Re: Response to Submissions – 88 Waterloo Road, Macquarie Park

This document has been prepared for Billbergia in response to City of Ryde Council Submission SSD-940006708 e. Tree Retention which states:

Arboricultural Impact Assessment Report (Revision C)

88 Waterloo Road
Macquarie Park
NSW

TREE REMOVAL / RETENTION PLAN

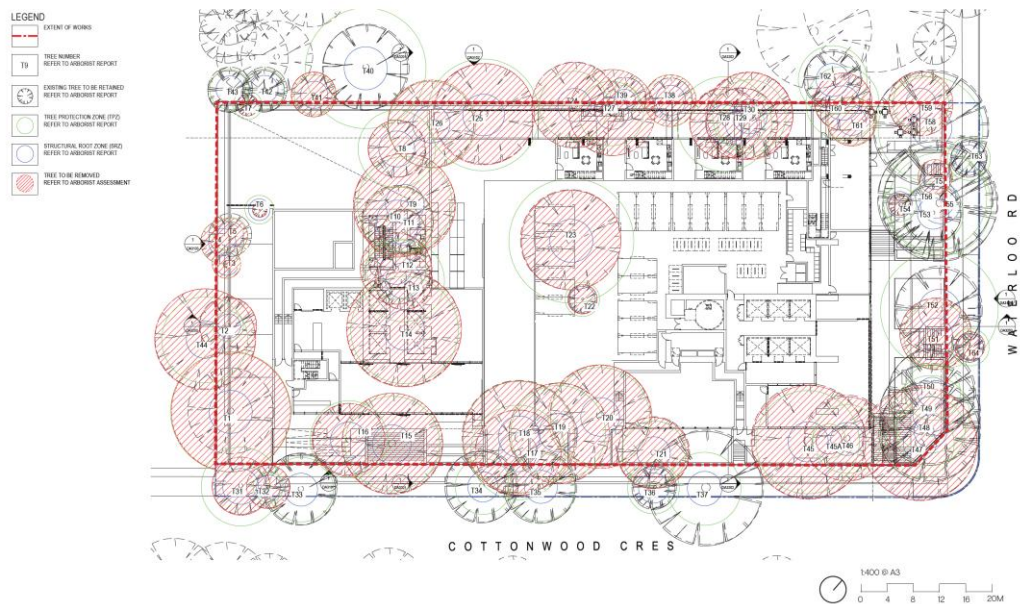
'Existing mature trees along site boundaries currently provide shade and environmental value. The provided tree removal and retention plan indicates that most trees will be removed. All mature trees should be retained to the street edge at both Cottonwood Crescent and Waterloo Rd. Council requires a detailed arborist report for the removal of any existing mature trees.'

Street trees T31, T32, T34 and T35 are to be removed due to either a direct conflict, or a Major Encroachment within their Notional Root Zone (NRZ) area (>20% - as defined by AS4970 Protection of trees on development sites) from the proposed driveway crossovers, or basement footprint. It is understood that the location of the driveways has been dictated by access requirements and therefore they cannot be relocated.

To offset tree removals and maintain the amenity and canopy cover within the streetscape, the Landscape Plans include the planting of seven (7) advanced size street trees.

Reserve trees 38 (weed species) and 39 (low value shrub) are to be removed due to a Major Encroachment within the NRZ area from the proposed basement footprint.

The design of the building footprint has been revised following submission of the SSDA. The current, proposal includes an increased basement set back on the western boundary which will allow for the retention of the neighbours tree T44.

It is understood that the retention of additional trees along the Cottonwood Crescent boundary of the site will not be possible due to design constraints. These trees have relatively large NRZ areas and setting back of the basement footprint to the extent that the trees could be retained would impact the developability of the site.

In response to submissions, with the exception of Trees T47, T54 and T59, the trees along the Waterloo Road boundary and within the nature strip in Waterloo Road are now being retained.

Tree T47 is in poor health and exhibits signs of significant decline, which reduces its useful lifespan and leaves the trees more sensitive to any disturbance within the root zone. It is unlikely that the tree would survive development works associated with the installation of the proposed stairs within its NRZ area.

Tree 54 cannot be retained due to conflict with the proposed pavement/building access. This tree is a small, low value specimen that is considered easily replaceable.

Tree T59 cannot be retained due to level changes at the interface between the site and the Reserve. This tree is in fair health and structural condition and has been colonised by termites.

In summary, the previous scheme had proposed the removal of forty-nine (49) trees. The revised scheme proposes the removal of forty-five (45) trees, including thirty-eight (38) trees on site and seven (7) trees outside of the site boundary within the reserve/verge.
